From: Anita Gardner
Sent: 13 December 2018 11:05
To: Planning.Responses
Subject: FW: 125 Sea Road, East Preston EP/136/18/PL
Attachments: ITL12278-SK-013 Revised Tracking 1of2.pdf; ITL12278-SK-014. Revised tracking 2of2.pdf

You may be aware of objections expressed by some neighbours to our site at the above address, concerning our planning application for a minor material amendment to rearrange the car parking spaces within our site.

This is logged under Arun Planning Ref: EP/136/18/PL.

TITLE: SWEPT PATH ANALYSIS - MEDIUM CAR - INTERNAL PARKING 1 OF 2	
PROJECT: SEA ROAD, EAST PRESTON	CLIENT: ROCCO HOMES

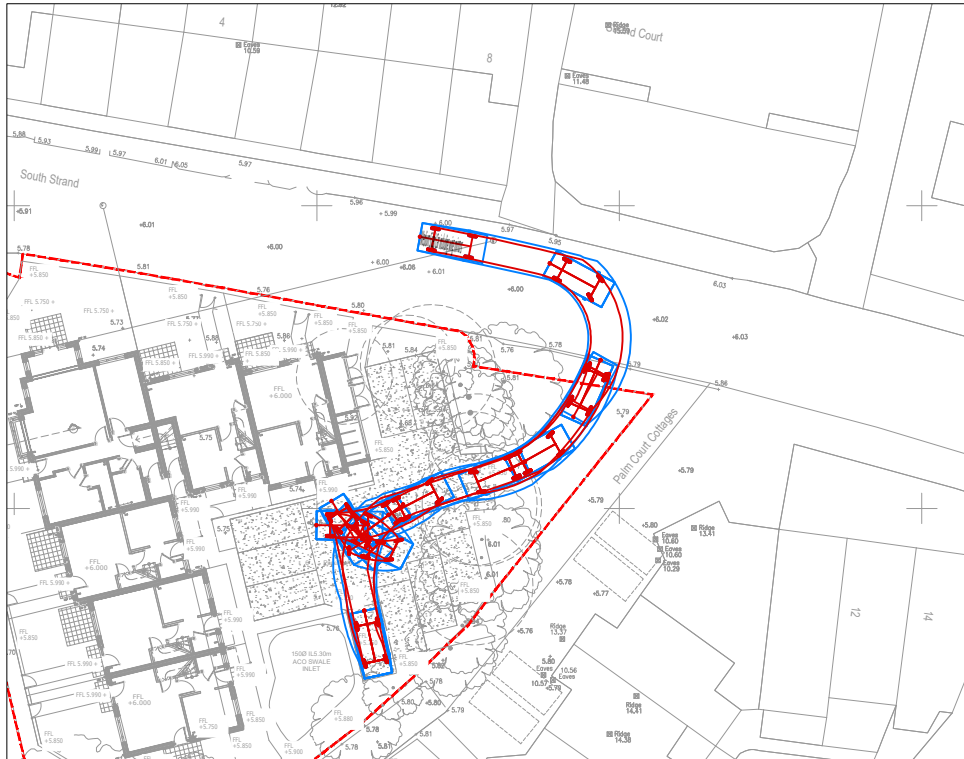
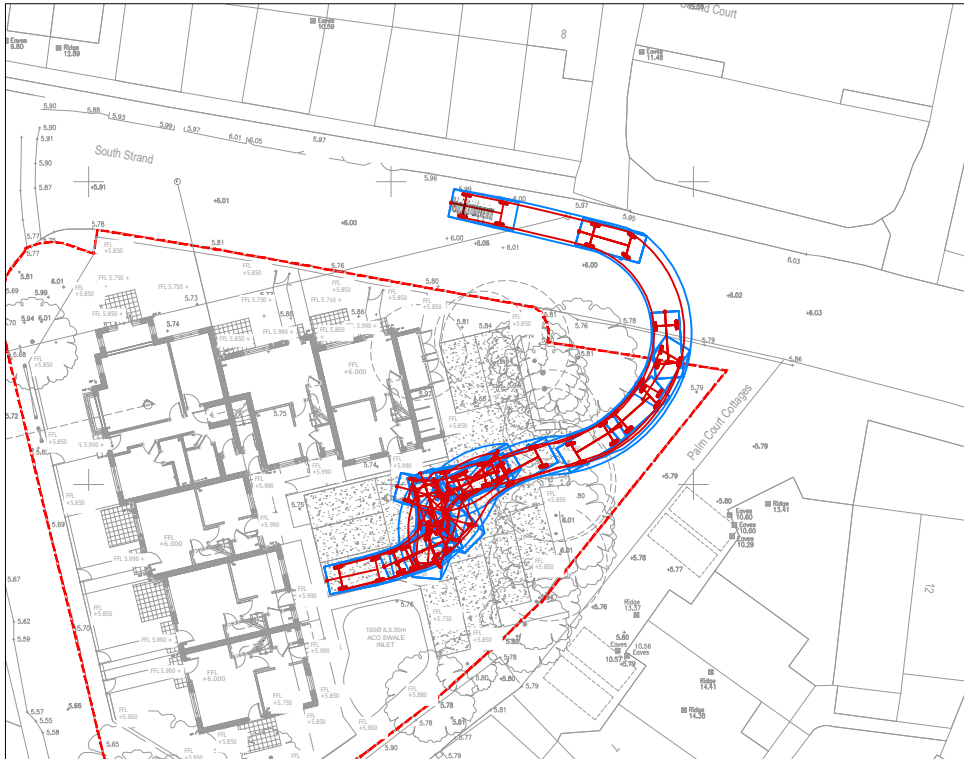
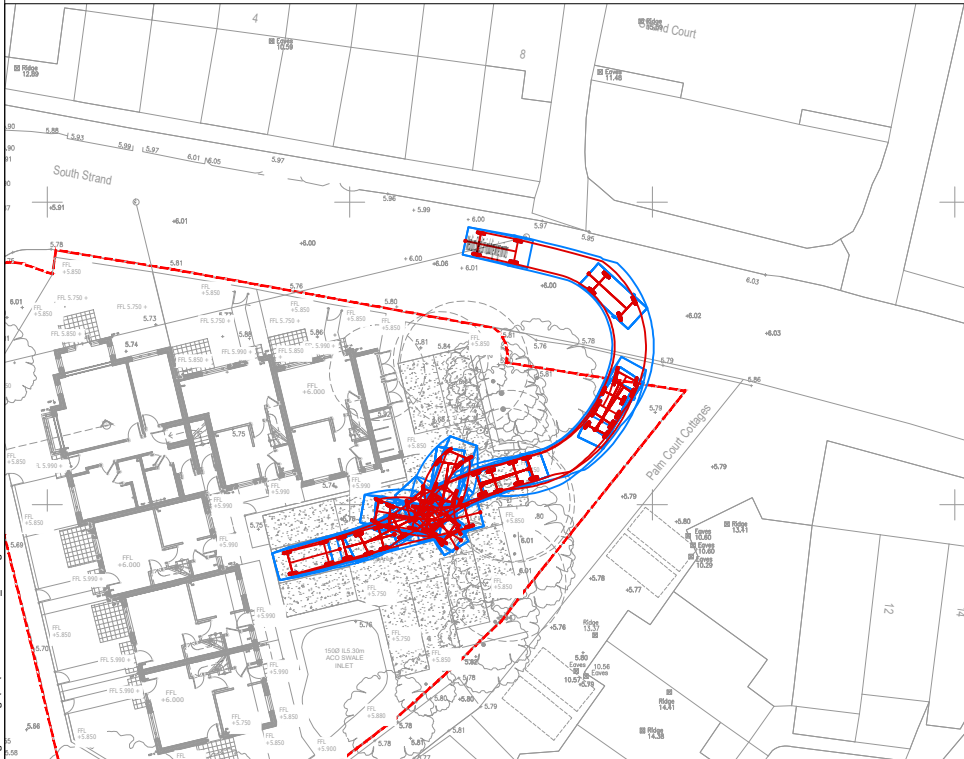
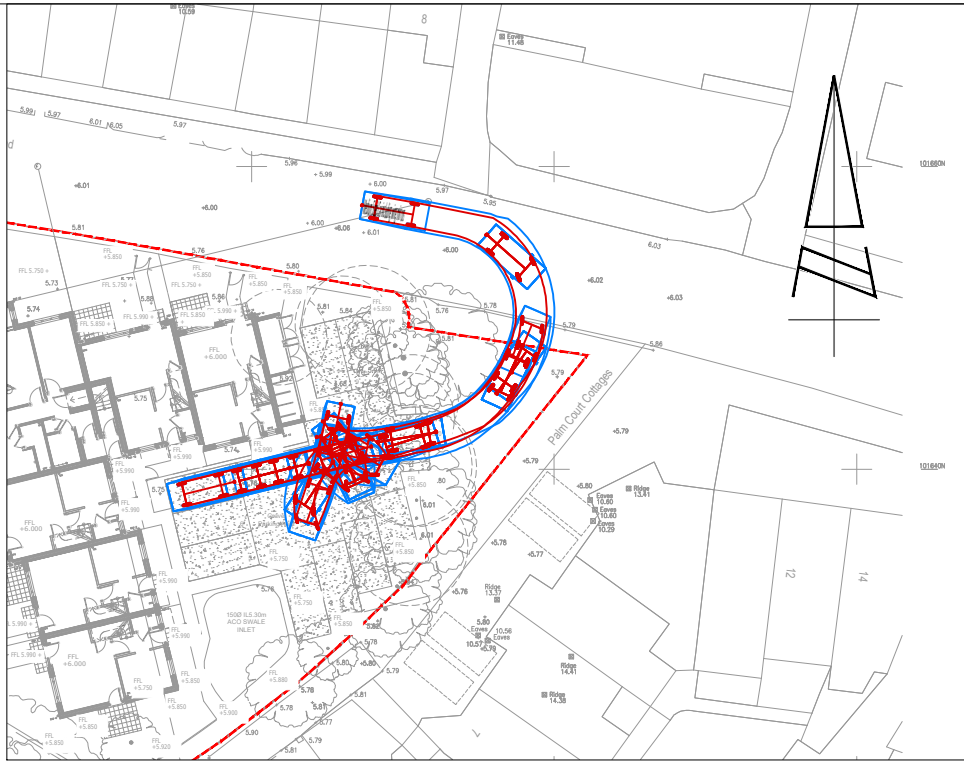
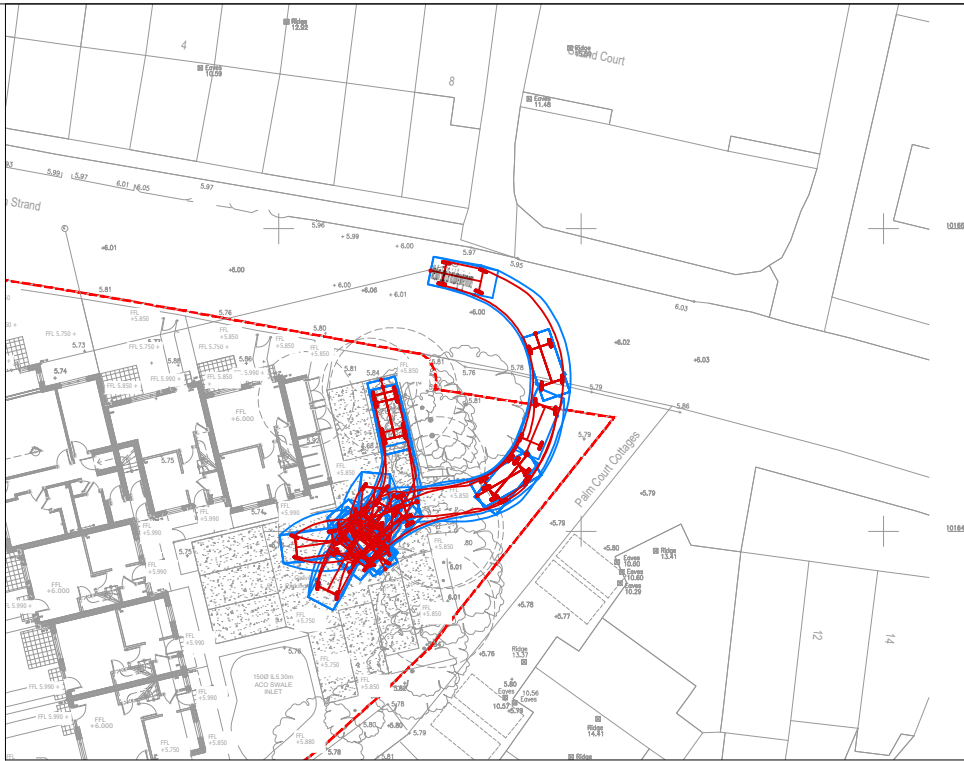
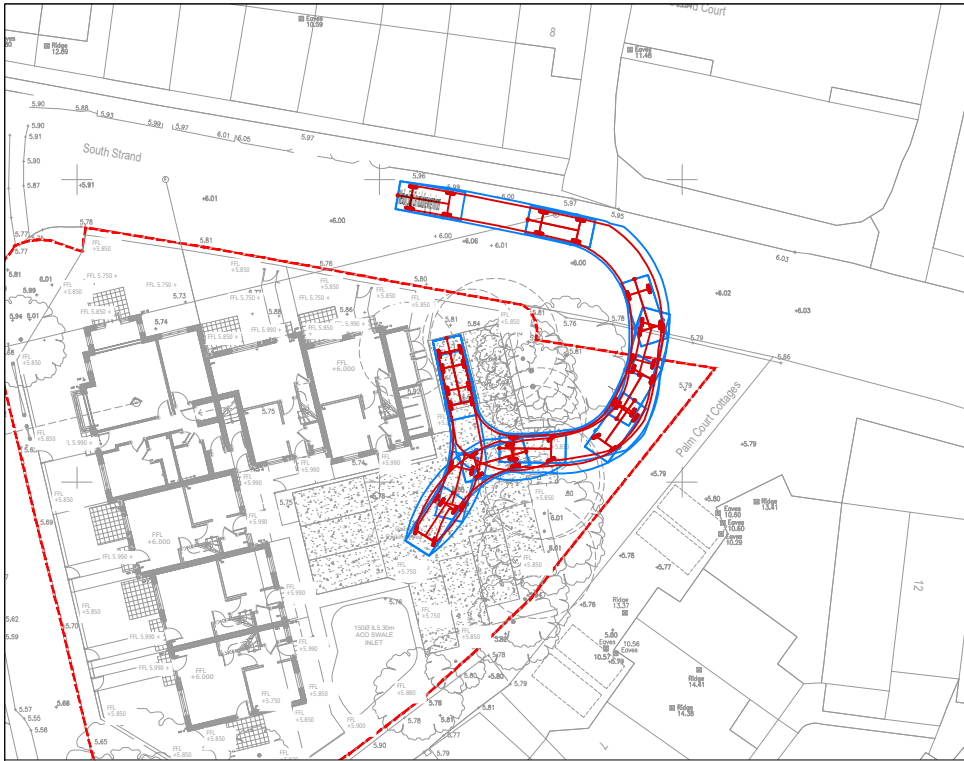
Please find attached the revised tracking drawing, which shows vehicle path to the site access over the triangle of land within our ownership.

Each space is accessible inwards and outward bound, with some requiring more than one movement within the site, but this is acceptable.
